**Colorado Springs, CO
Planning and Development**

Final Report - Corrections Required
Application No. ANEX-23-0014

Description : A request by Norris Ranch Joint Venture, LLC, for annexation of 19.605 acres into the City of Colorado Springs. The annexation is a part of the overall Karman Line Land Use Plan, which is being submitted concurrently. The Land Use Plan proposes a maximum of 6,500 dwelling units, approximately 45 acres of light industrial, 105 acres of commercial/retail, 100 acres of mixed-use development, and 570 acres of park/open space.

Document Filename : Plat

ANNEXATION PLAT KARMAN LINE NO. 6

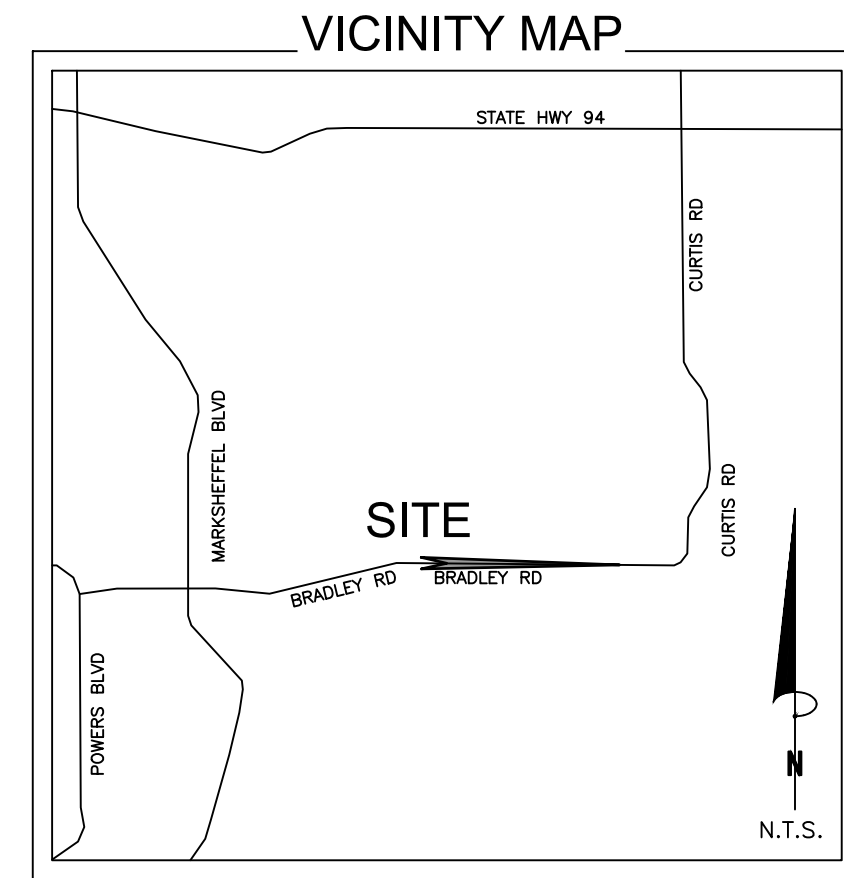
Please update the name Karman Line Addition No. 6 on all sheets

Please remove El Paso County. The current portion of Bradley Road that is County right-of-way will need to be deeded to the City of Colorado Springs by separate instrument

Please revise too: contiguous perimeter percentage: 19.04%

Please check/revise the total (my calculation is 26263.43')

Please add the calls along Karman Line Addition No. 5

Please update the ownership: Owner: The aforementioned, City of Colorado Springs, Colorado, a home rule city and Colorado Municipal Corporation, has executed this instrument this ___ day of _____, 20__ A.D.

Please update the Recorder's name Steve Schleiker, Recorder

Please update the City File No. ANEX-23-0014 on all sheets

ANNEXATION PLAT KARMAN LINE NO. 6

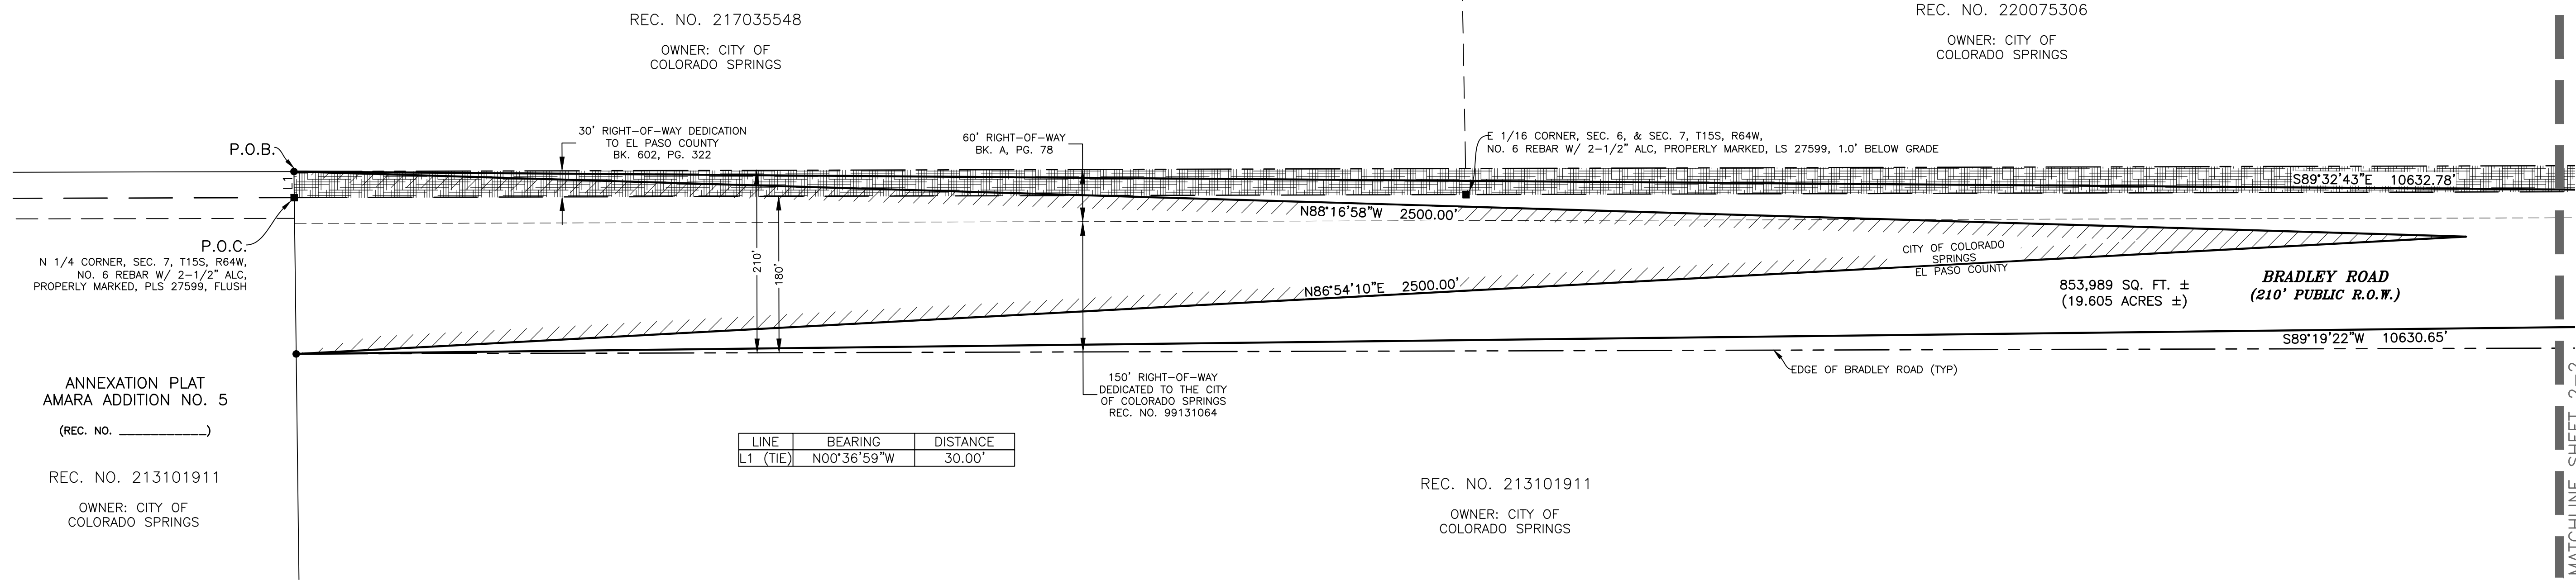
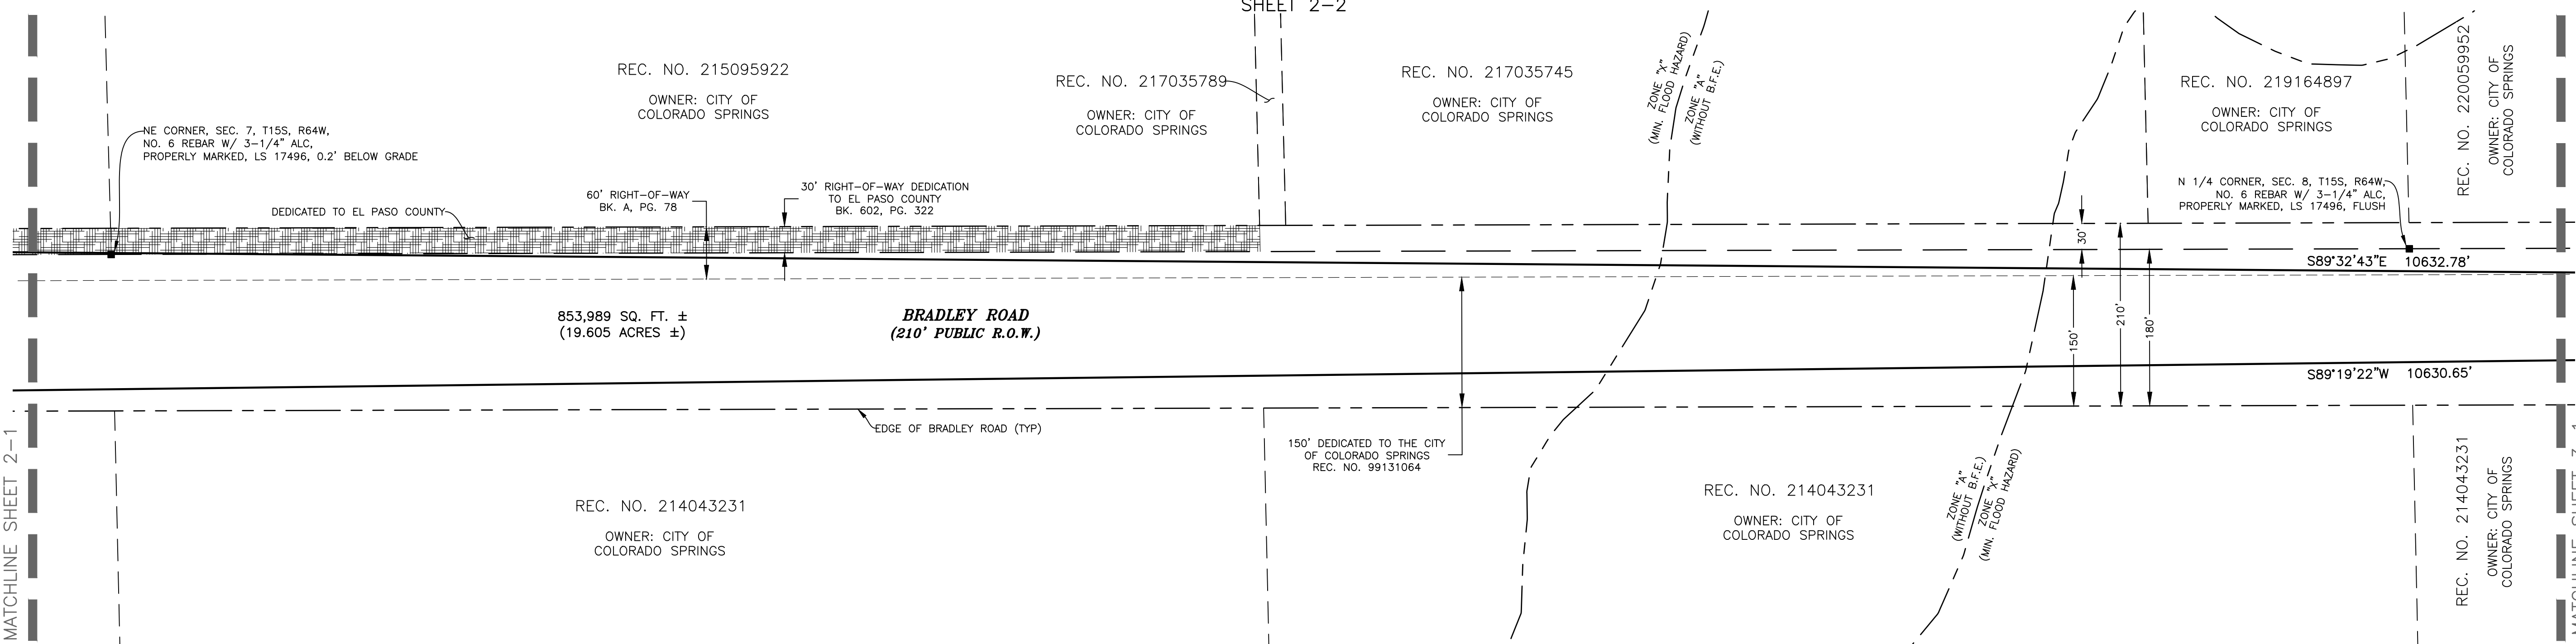
Please update the annexation plat names

Please remove El Paso County. The current portion of Bradley Road that is County right-of-way will need to be deeded to the City of Colorado Springs by separate instrument

Please update the name Karman Line Addition No. 6 on all sheets
